Application Reference: 2026/0185

Site Address: 17 Columbia Street, Worsbrough Common, Barnsley, S70 4LE

Proposal: Erection of two storey side and rear extension.

Drawing Title
Proposed Elevations
A3

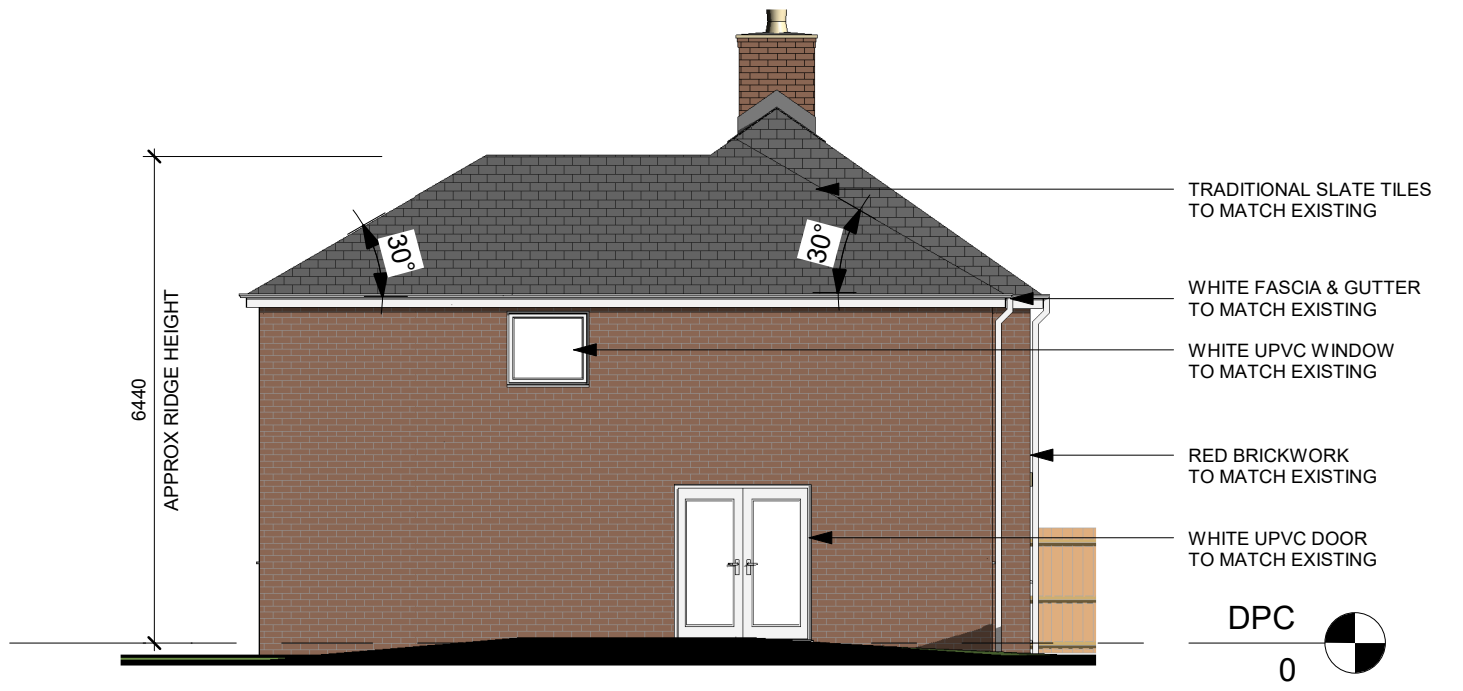
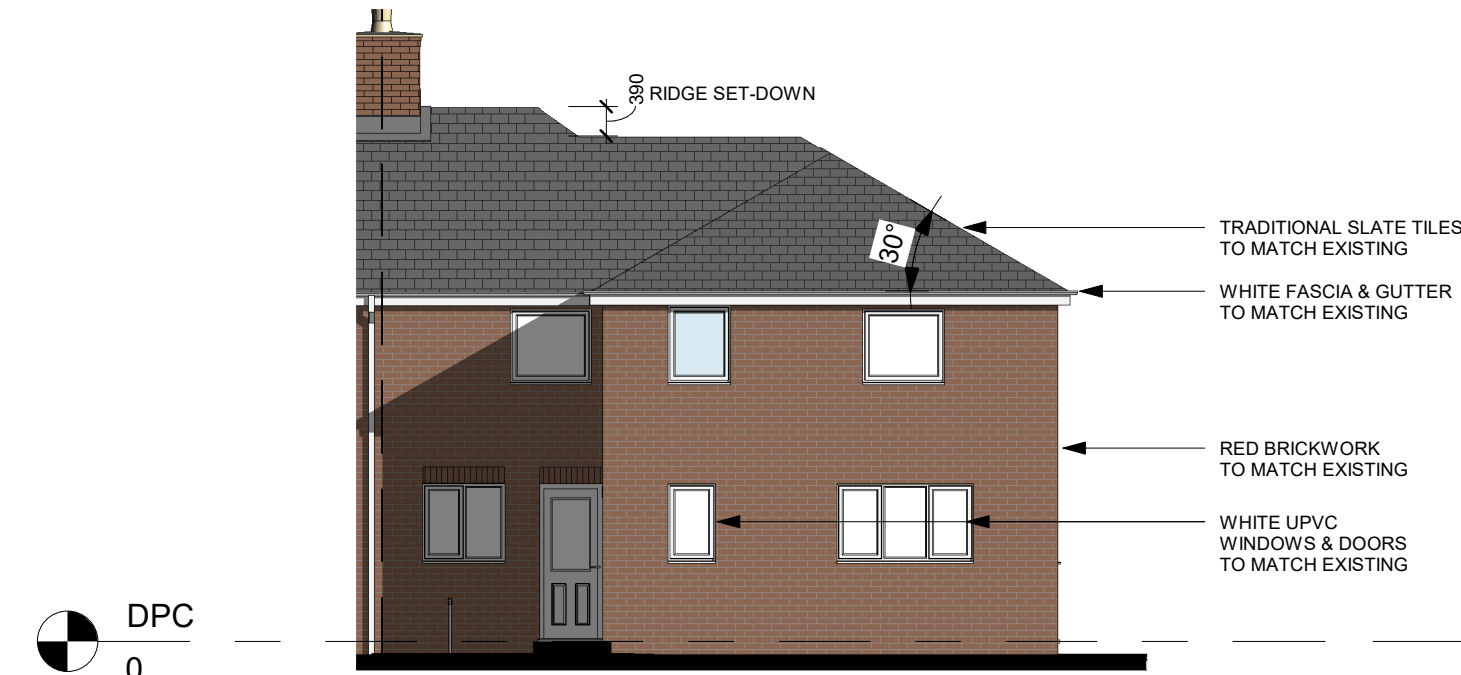
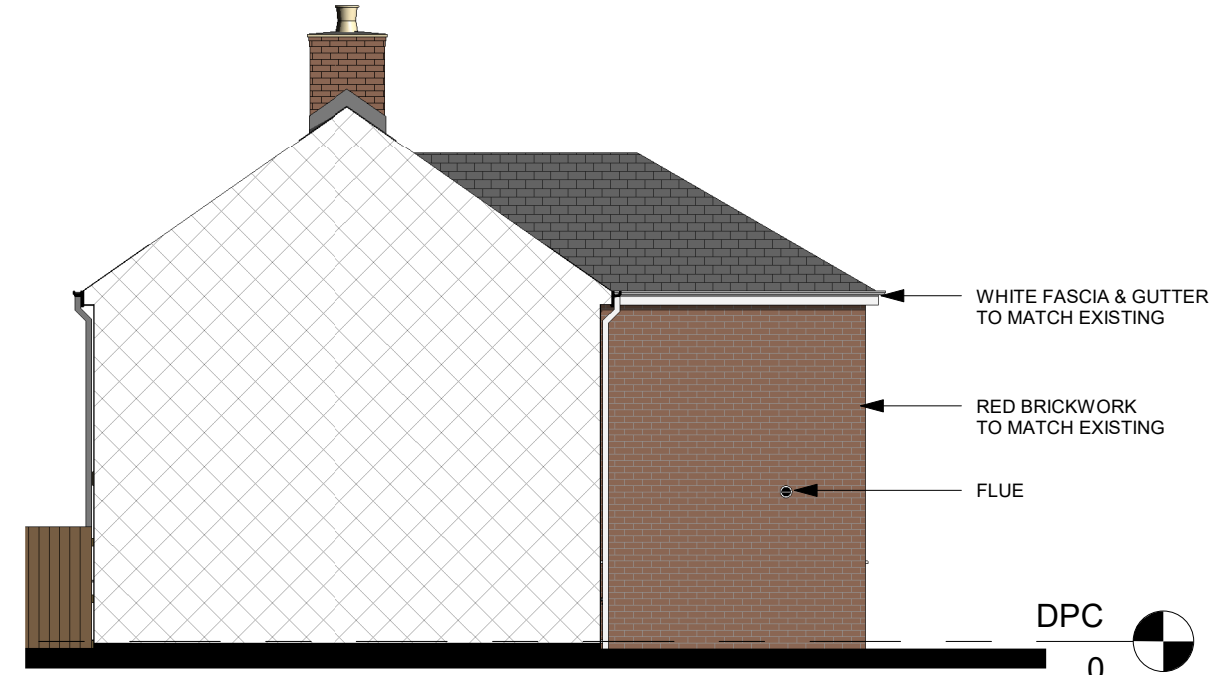
The applicant is seeking permission to erect a two-storey side and rear extension. The proposed side extension would have an approximate sideways projection of 3.5 metres and a proposed length of approximately 9.7 metres. A hipped roof form has been proposed with an approximate eaves' height of 4.6 metres and an approximate ridge height of 6.8 metres. The side extension has been set back from the front elevation by approximately 0.5 metres and set down from the ridge by approximately 0.39 metres.

The rear extension would project to the rear of the dwelling by approximately 3.5 metres and would have an approximate width of 6 metres. The extension would provide a hipped roof form with an approximate eaves' height of 4.6 metres and an approximate ridge height of 6.4 metres. The rear extension would be set to the south of the adjoined property by approximately 2.9 metres.

The proposed side extension provides an acceptable sideways projection of less than two thirds the width of the existing dwelling. The side extension is set back from the front elevation and down from the ridge ensuring the proposal is subordinate to the existing dwelling. The use of a hipped roof form allows the proposal to remain in keeping with the site and the street scene.

It is noted that the 2 storey side and 2 storey rear extension combine resulting in a large side elevation, however, given the position and angle of the dwelling it is not highly visible from public vantage points and would not result in a prominent or dominant feature on the street scene.

The proposed rear extension provides an acceptable 3.5 metre rearward projection as outlined within the House Extensions SPD. A hipped roof form has been proposed which matches the existing roof form and integrates into the proposed side extension roof form.

The proposed rear extension would be erected to the south of the adjoining property. Rear extensions should avoid causing detrimental overshadowing to adjoining neighbours especially when to the south. Given the rear extension has been substantially set away from the adjoining neighbouring property, any possible overshadowing caused by the proposal would be reduced. In addition, the use of a hipped roof form allows for a lessened impact from the proposal as well as the set down of the ridge. The proposed rear extension would not intersect the 45-degree angle of the nearest neighbouring window. Given the above, the proposed rear extension would not overshadow or be overly dominant to a detrimental level. No side elevation windows have been detailed to face the adjoining property, preventing any opportunity for direct overlooking.

A window is acknowledged to be detailed to the south facing side elevation to service a bedroom. Although the window is acknowledged to allow for some overlooking to the south, given the orientation of the dwelling is at 45 degrees to 18 Columbia Street, it would predominantly face the far rear amenity space to the south at a significant distance. It is therefore considered the window would not result in detrimental levels of overlooking. Additionally, letters have been sent to neighbours inviting comments relating to the proposal. No representations have been received.

Amendments were requested during the application process to reduce the sideward projection, roof type and rearwards projection of the proposal to align with policy.

Drawing Title
Proposed Floor Plans
A1

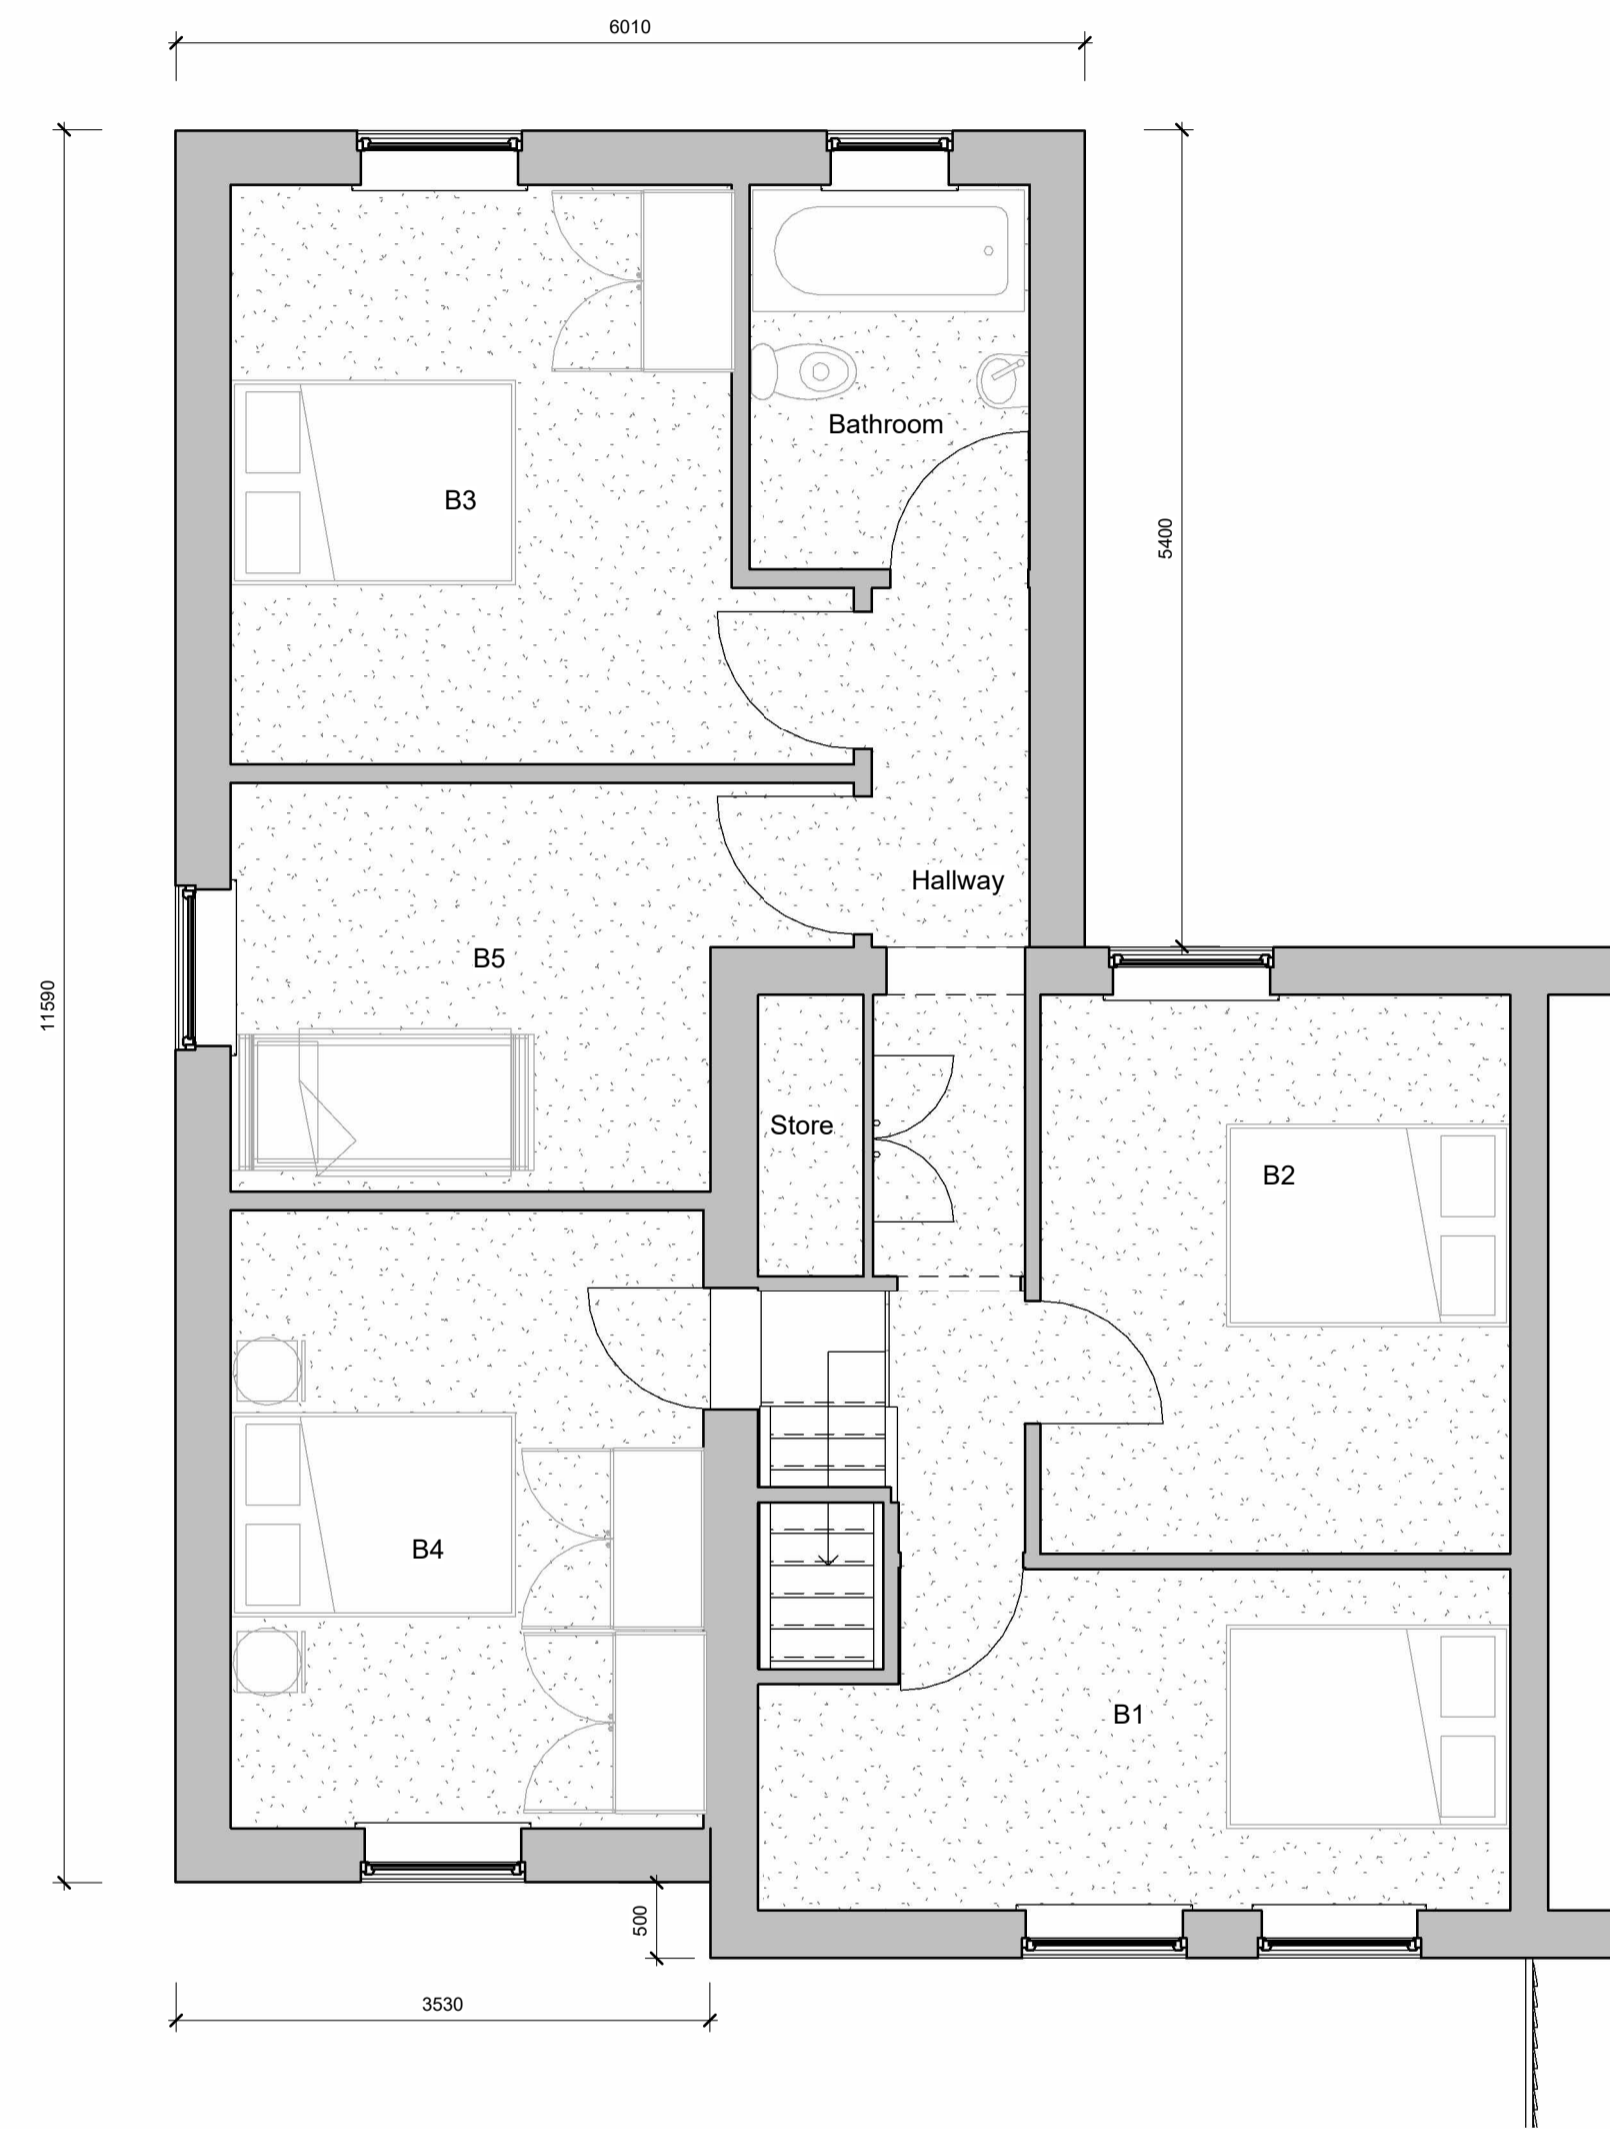
The rear window servicing a bathroom shall be conditioned to be obscured glazing in order to protect the privacy of the applicant and neighbouring properties to the west.

The proposal would increase the number of bedrooms on site from 2 to 5. The site facilitates parking for 2 vehicles and is therefore considered to be sufficient.
